From: Jeff Watson
Sent: Tuesday, January 19, 2016 1:11 PM
To: shirley riste (bnsriste@gmail.com)
Cc: Holly Myers; Holly Duncan
Subject: FW: Notice of Application: SP-15-00007 Riste

NOTICE OF APPLICATION: SP-15-00007 RISTE

Kittitas County Community Development Services has received the above referenced application for a 3 lot Short Plat off of Canyon Road near the southern border of the county. See attached documentation for additional information or use one of the hyperlinks above to access the on-line or network file. Comments within the body of an email are encouraged but may be sent as attachment or via USPS as a hard copy.

DRAWING TYPE: SHORT PLAT APPLICATION

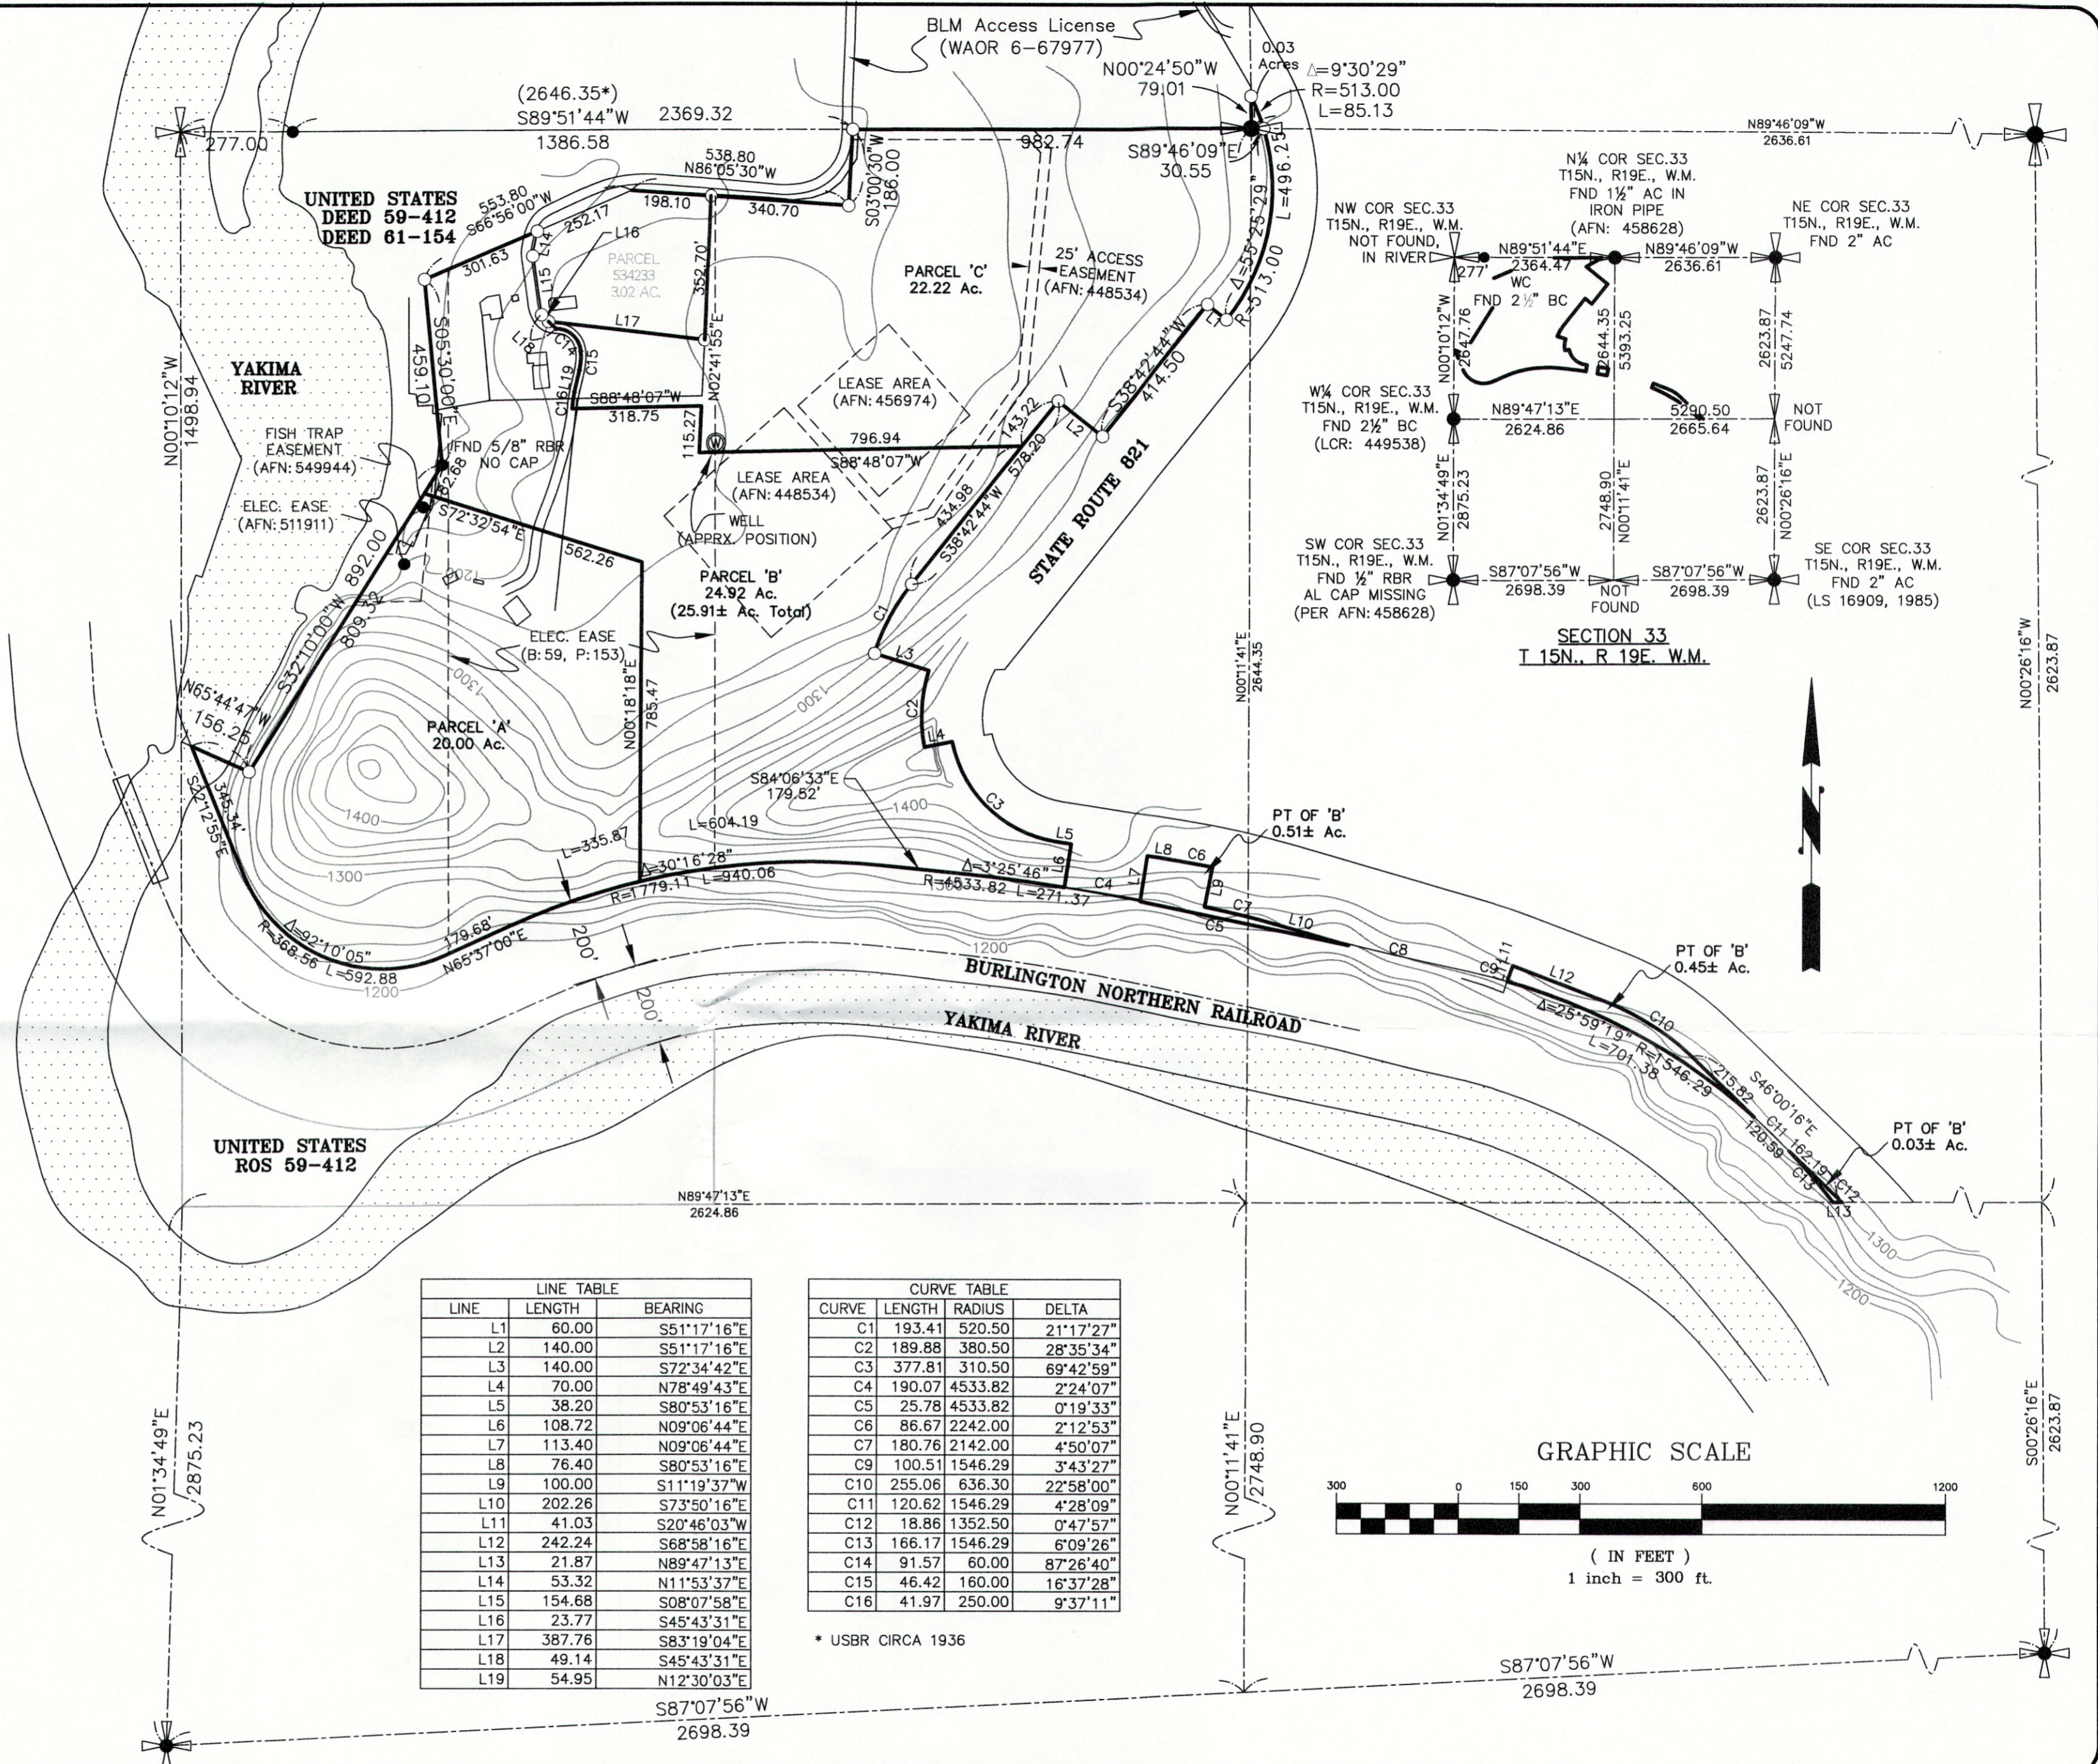
The folks down at Public Health have some concerns about the distance from the well on Parcel C (see below); it needs to be 50 feet from the property line or there needs to be a shared well agreement in place. I don't know if they will require this information before they can issue a comment letter or whether it will be incorporated into the conditions for final approval. You might check with Mr. Gray and see if he has a number for the distance, or you may have to adjust the property line on the final plat, or again a shared well agreement. Give me a call if you have any questions.

The well that is located on the proposed parcel C may not be the required 50 feet from the property line. Does this mean the well will be proposed as a shared well between parcels B and C if it isn't 50 feet from the shared property line?
